PAQUETTE PLANNING ASSOCIATES LTD.
URBAN PLANNING AND LAND DEVELOPMENT CONSULTANTS

Re: Zoning By-law Amendment D02-02-21-0008 and Site Plan Control D07-12-21-0015
120 Den Hagg Drive
Phase 1

Circulation Comments and Responses

DATE (aa mm ii)
 2020.10.21

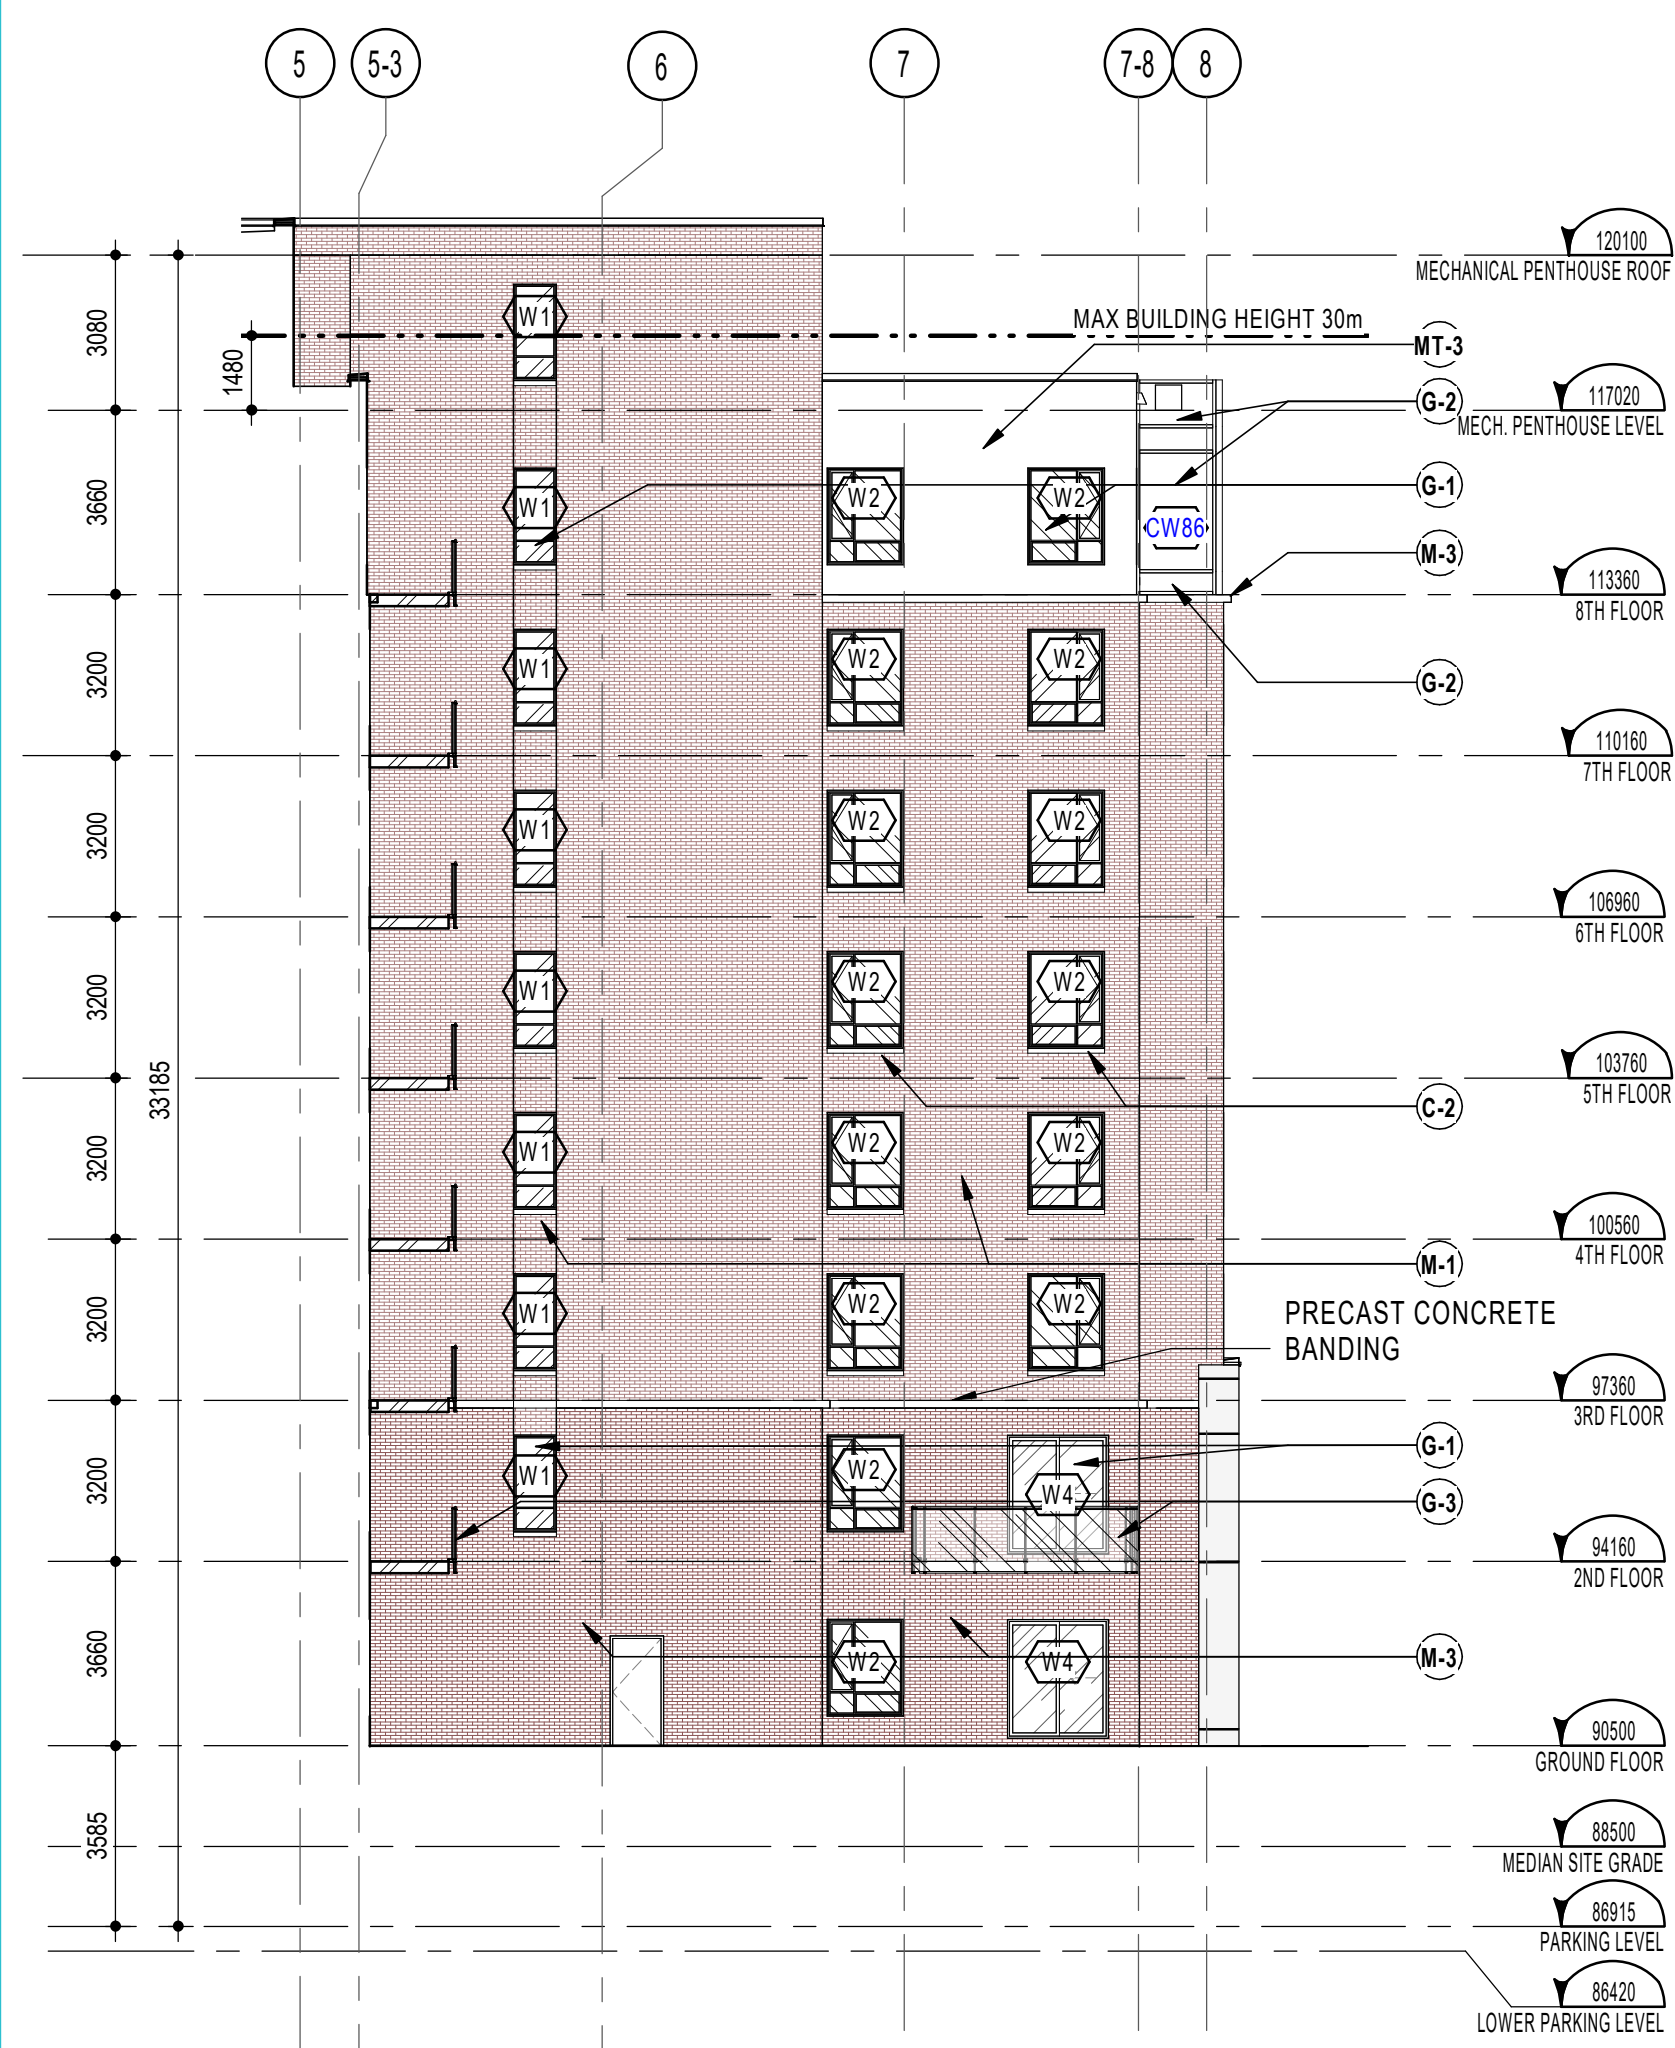
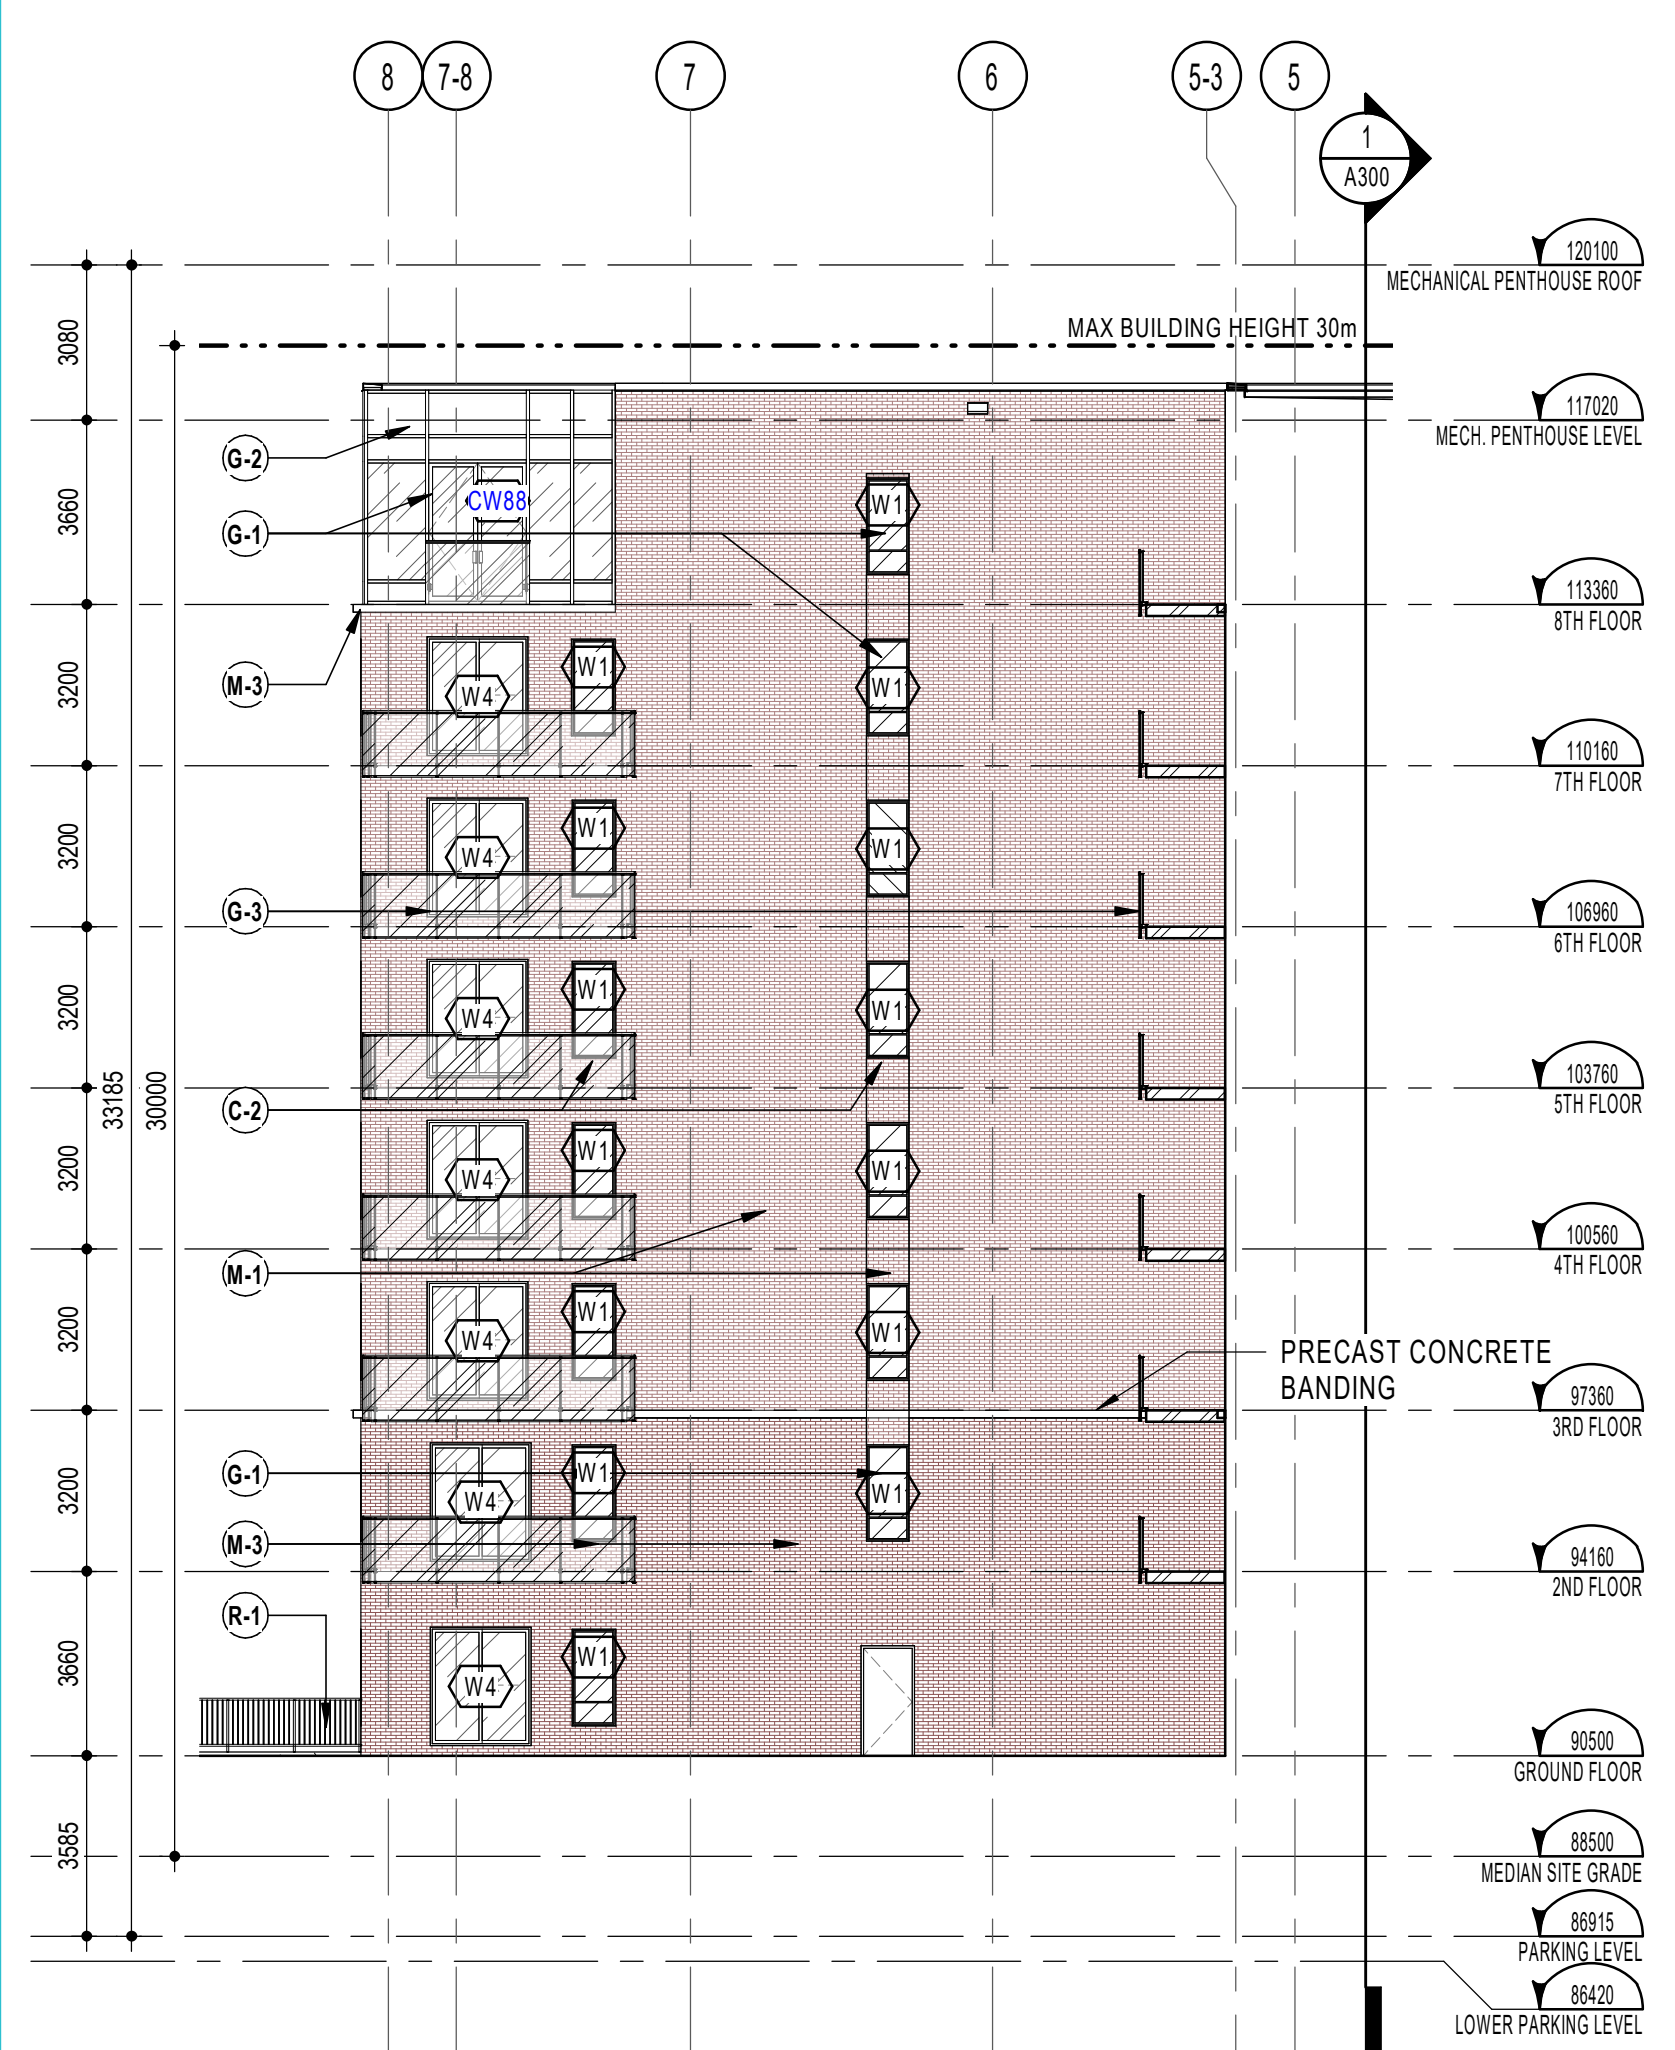
2.a• The Panel has concerns with the street facing projected balconies, especially at the corner, making the building feel top-heavy. The proponent should consider in-setting the balconies at the corner and explore recessing or integrating all of the street facing balconies to strengthen the project as a street wall building.

2.c• The Panel recommends further refinement of the façade by removing the columns at the corner and creating a cantilever expression to simplify the base.

3.a• The Panel believes the building should be simplified as the base and top have different patterns of glazing and mullions, making the top appear taller.

3.b• The contrast of dark masonry at the base with the red brick middle portion needs further study. The changes in materiality appear co-planar, and the dark brick

between the windows does not successfully add depth or articulation.

3.c• The proponent should consider using contrasting colours to make the top lighter, establish a clear and consistent datum line where the material changes to glass and simplify the two-storey base.

3.d• The Panel appreciates the use of red brick and cautions that the white metal that currently extends to grade will be difficult to maintain; a material with greater durability and permanence (such as stone or precast) may be considered.

Response: Balconies revised to add more interest to the corner. 8th floor corner unit is recessed separating building top from middle. The light steel framing system chosen has limitations. The light steel frame requires a simplified load distribution from roof to foundation. Embedding balconies would interfere with loads and create additional structural elements.

Response: Removing Column at the corner and cantilevering the 3rd floor would cause structural concerns. Reducing the cantilever would affect the base, middle, top separations.

Response: Noted. Mullions and glazing spacing has been revised to project elements from the middle of the building into the 8th floor, and ground floors.

Response: Dark masonry removed from between windows. Masonry detailing between windows have been added to break up façade and allow for some differentiation, and interest between windows.

Response: 8th floor has been revised to a lighter colour. A datum line complete with architectural masonry element has been included at the 2nd floor added to separate a darker red back from a lighter red middle. Clearly separating base, middle, and top separations.

Response: Noted. Limestone base at all grade are provided for durability.
